DCO Hearing ISH1 on draft DCO, Tuesday 27 September

re: Requirement 20 – Decommissioning & Restoration

DCO Hearing ISH2 on Environmental Matters on Thursday 29 September

ELAF submissions re permissive paths / greenway, Access for All and Public Rights of Way (PROWs)

NO	DATE	DESCRIPTION
P02	03/10/2022	FOR DEADLINE 3
P01	23/02/2022	FOR DCO SUBMISSION
I/R	DATE	DESCRIPTION

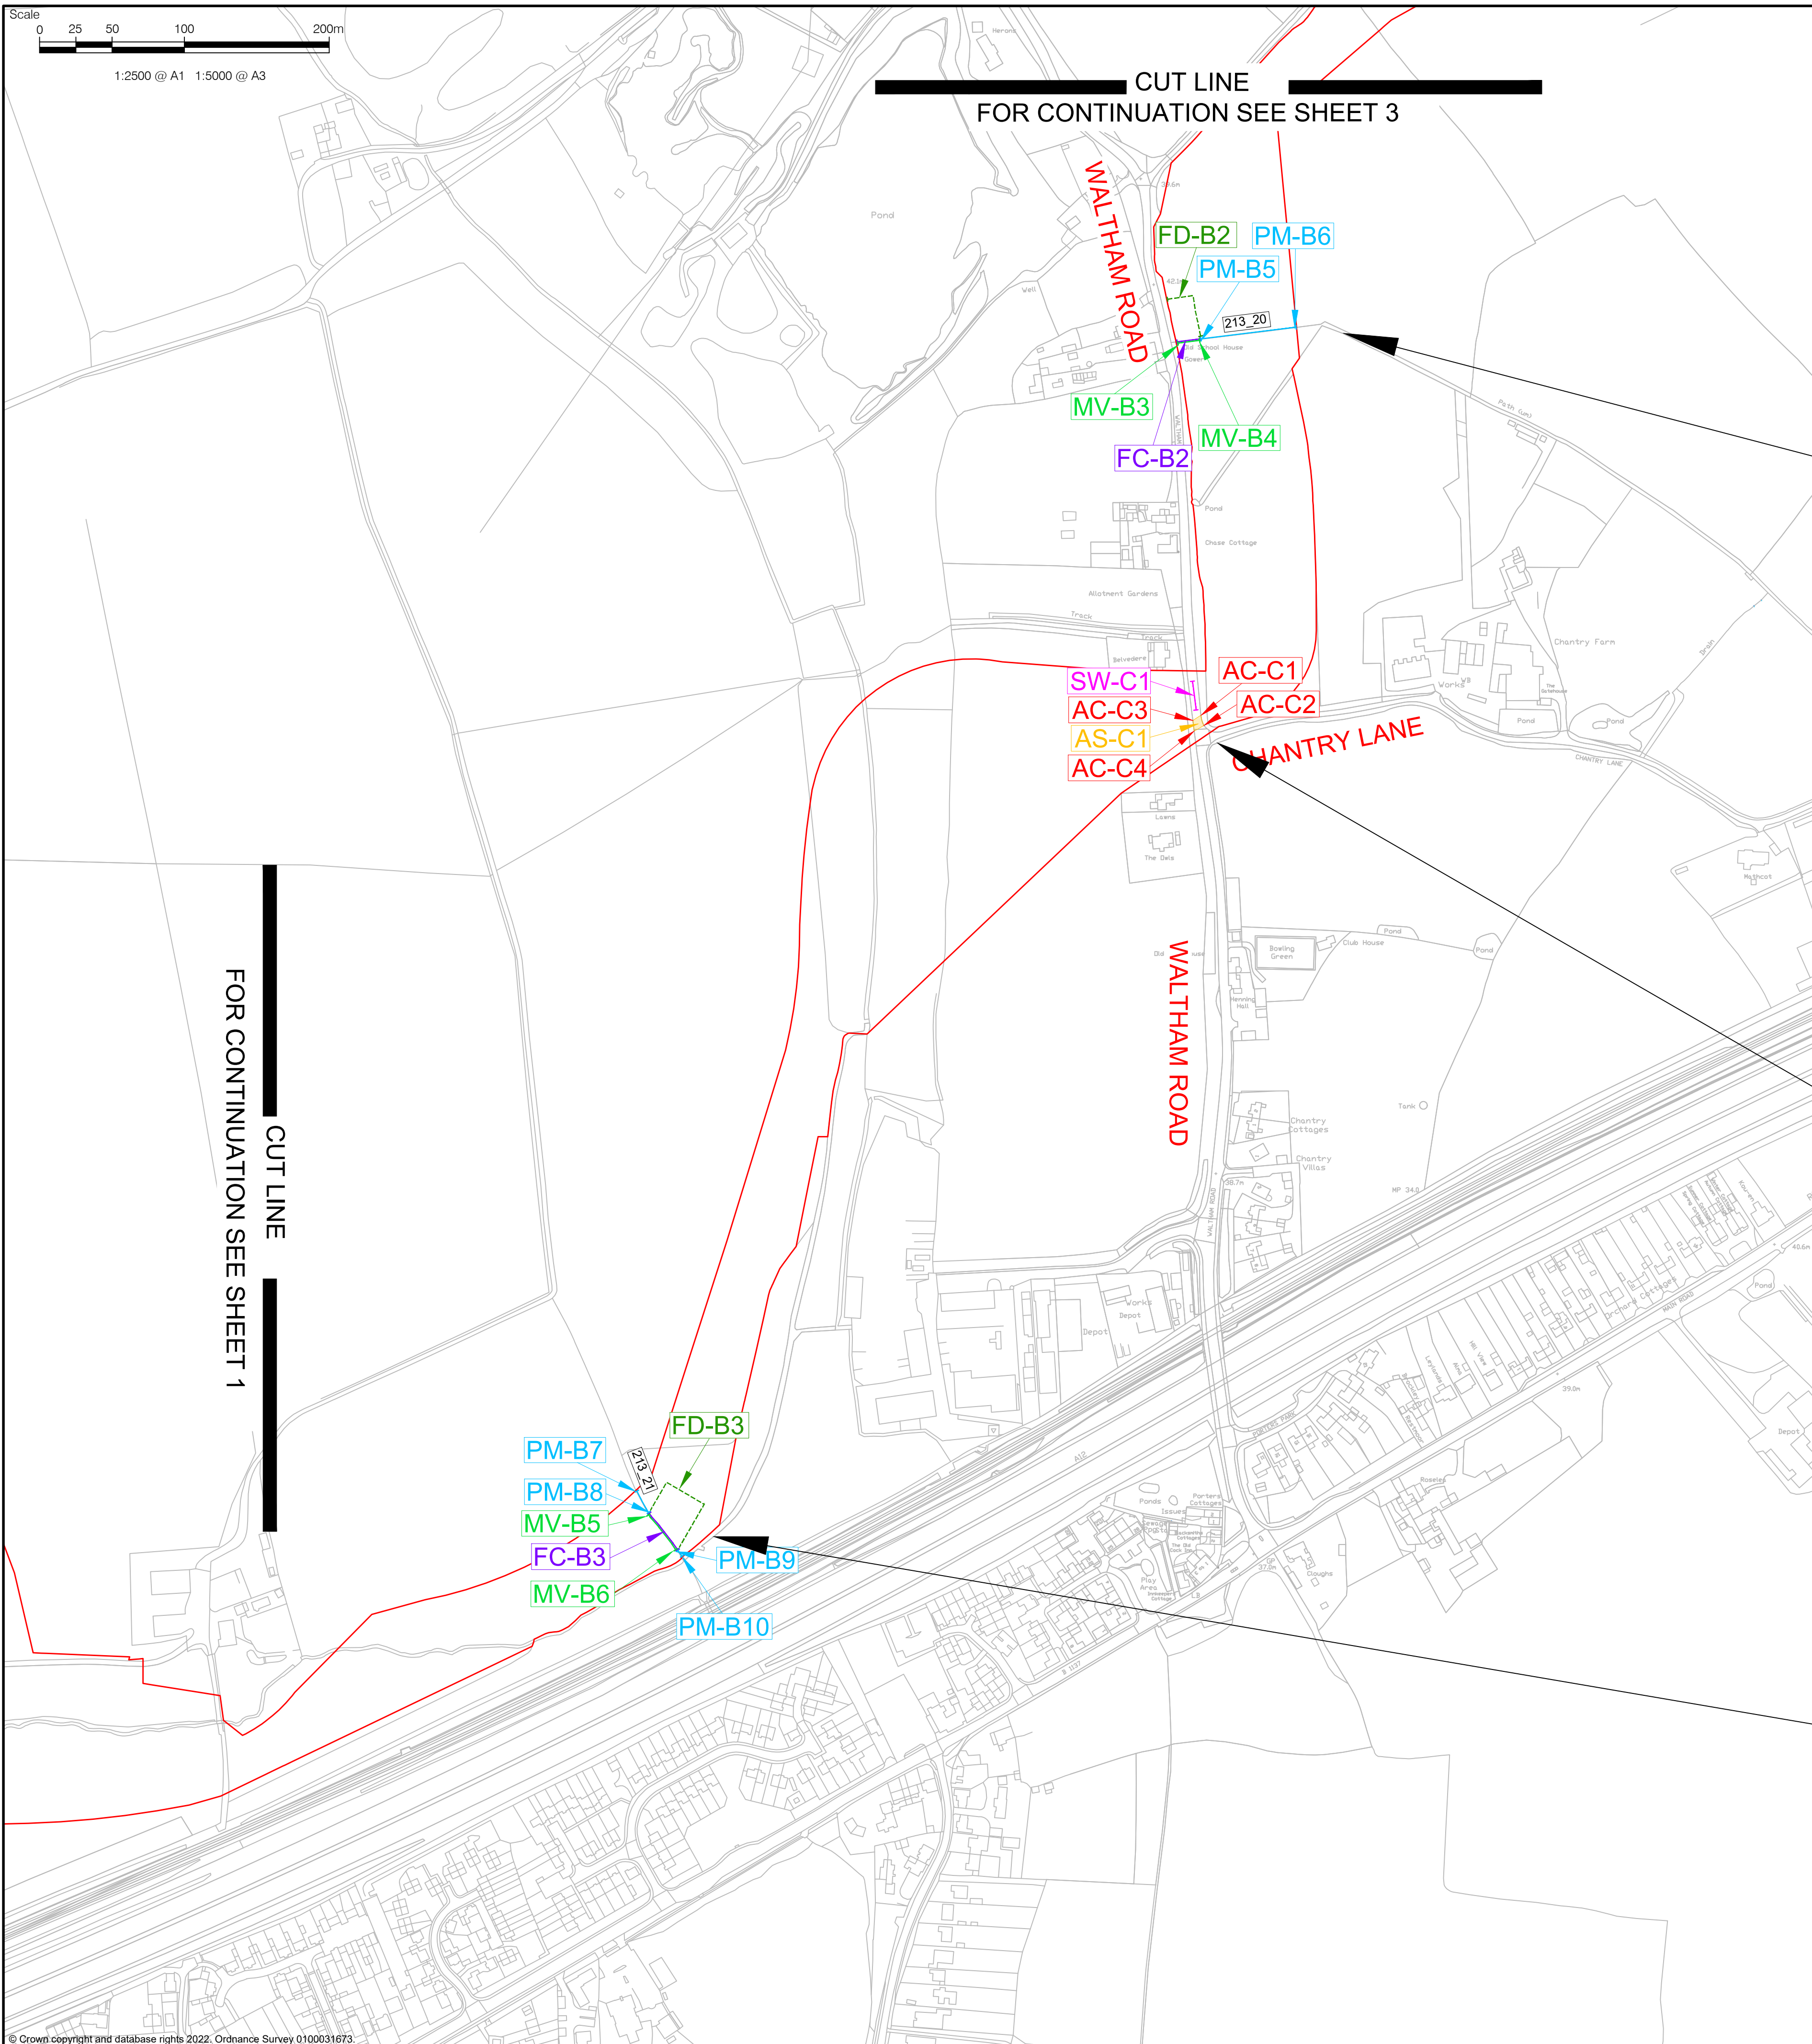
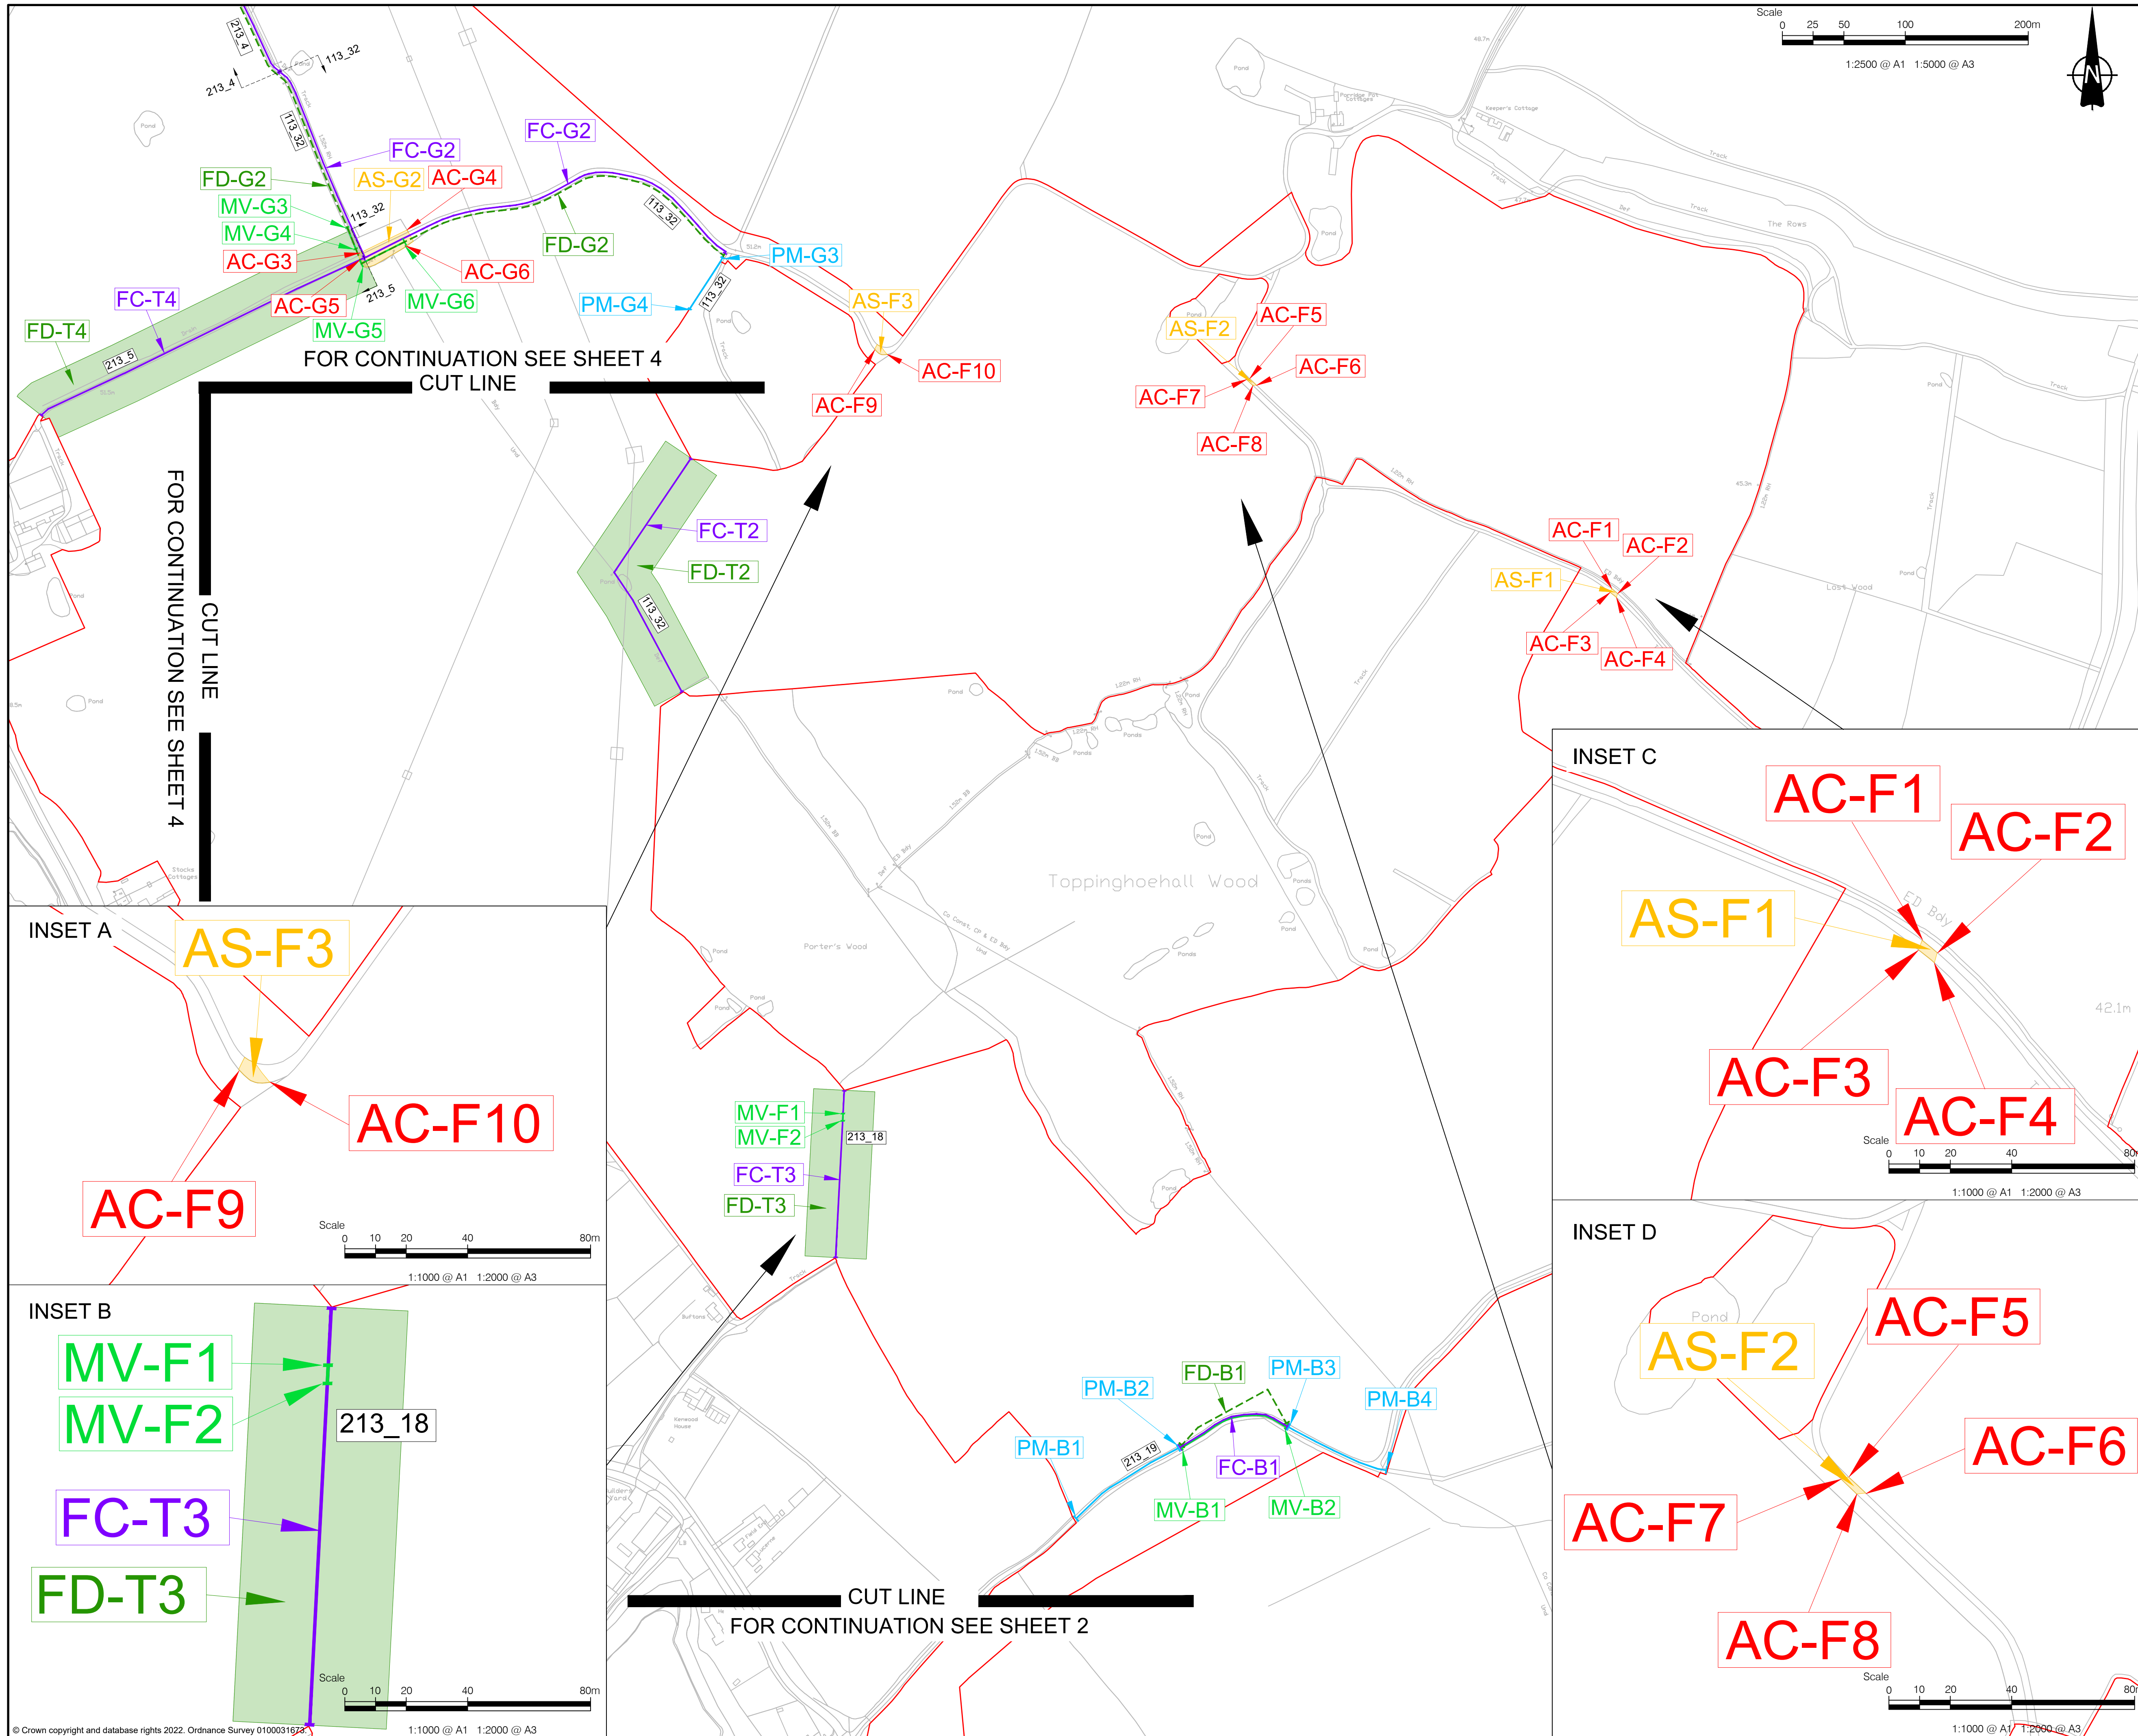
- (3) The permissive paths plan does not actually show the vehicular access routes. However, when looking at the Streets (and Access and Rights of Way) plans a lot of the permissive paths appear to be on the same line as the vehicular access tracks. The applicant said that the paths would be separated from the vehicular tracks during construction for health and safety purposes.
ELAF also noted that where a permissive path runs alongside or very close to vehicular access routes, it is not clear what the width of the permissive path will be, what the nature of the surface will be or whether there will be any vegetation or anything on either side of the path. Reference was made to Examination Library Reference document REP2_029 which was the applicant's written response of September to submissions made, including ELAF's submission (page 72 onwards). Mrs Evans of ELAF apologised for being unaware of this document.

(3) ELAF are concerned about the surface of the public rights of way which are going to be dug up to have cables run underneath them – labelled FC and coloured purple on the Streets (and Access and Rights of Way) Plans and listed in Schedules in the Order. Do the cables have to go under the public rights of way? Could they not go alongside or somewhere else inside the solar farm fencing? The digging up is not just for short lengths across a public right of way but sometimes also for 300 or 400 metres along a public right of way. The applicant said that the public rights of way will be reinstated to the same condition afterwards – as far as is possible / practicable.

The applicant confirmed that these PROWs will be closed for short periods during construction in a rolling programme whilst the cables are installed and the land is restored and so no diversions are justified / considered to be needed.
